DECISION DELEGATED TO DEVELOPMENT MANAGER

Application No: H01-0203-20 **Applicant:** Broadgate Homes Ltd
Proposal: Residential development comprising 4 detached bungalows and garages
Location: Land To Rear Of 75 Backgate Cowbit Spalding
Terminal Date: 22nd October 2020

Figure 2: Locations of the hedgerows and trees on site

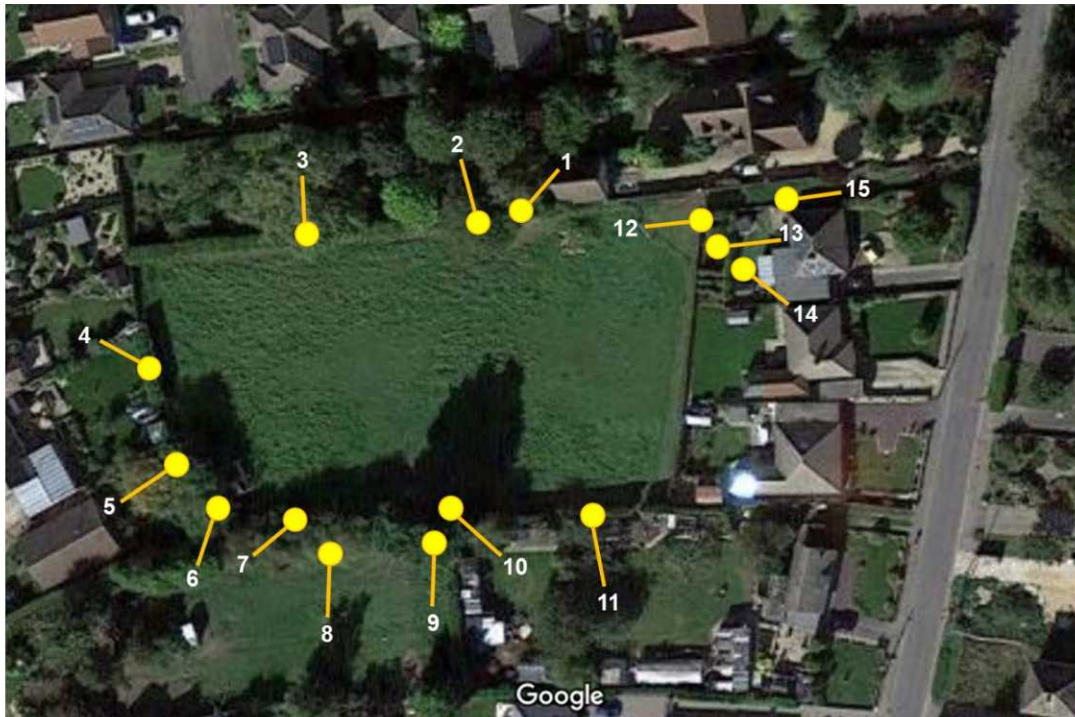
Photographs show young maple trees growing in the adjacent property to the north of the proposed entrance to the site. Their Root Protection Areas will need respecting when the roadway into the site is constructed. It would appear that it is proposed that a small area of amenity land laid to grass will be situated close to at least three of them. They have great growth potential.

A fine holly appears to be situated near the entrance to the site, probably in the most northern part of the property known as 77 Backgate. Again if retained the Root Protection Area should be respected. Maybe the small triangle of proposed gravel between the gardens of 77 and 75 Backgate will help this.

The only other trees which appear of note on the site are firstly a Norway maple tree on the northern boundary, which has damaged bark likely to have been caused by grazing animals nibbling it many years ago, callus tissue has formed around the edge of the wounds. (It was also noted that the trunk has grown around a piece of iron likely to have been used as a tree stake or maybe part of a fence); Secondly a cypress tree, possibly a Monterey cypress, or it could be a Leyland cypress (assume it is one tree rather than a close group); photographs were not detailed enough to determine the species. From the photographs am not exactly sure of the position of the cypress tree in relation to the boundary, likely to be on the southern boundary.

The Norway maple appears to have been taken into account in the proposed plans and has a small grassed area adjacent to it. The cypress may be adjacent to a back garden. It would have been helpful for its long term future if the proposed layout had situated a communal or amenity area adjacent to it.

Trees/hedgerows along the western boundary are fortunately adjacent to an easement strip which would appear to be covered in gravel according to the plans. Hopefully this is to be laid using 'no dig' techniques within the Root Protection Areas.

1. Usual conditions required to ensure that trees on and bordering the site have their Root Protection Areas respected. All trees and hedgerows to be protected as recommended in British Standard 5837:2012, before works on site commence.
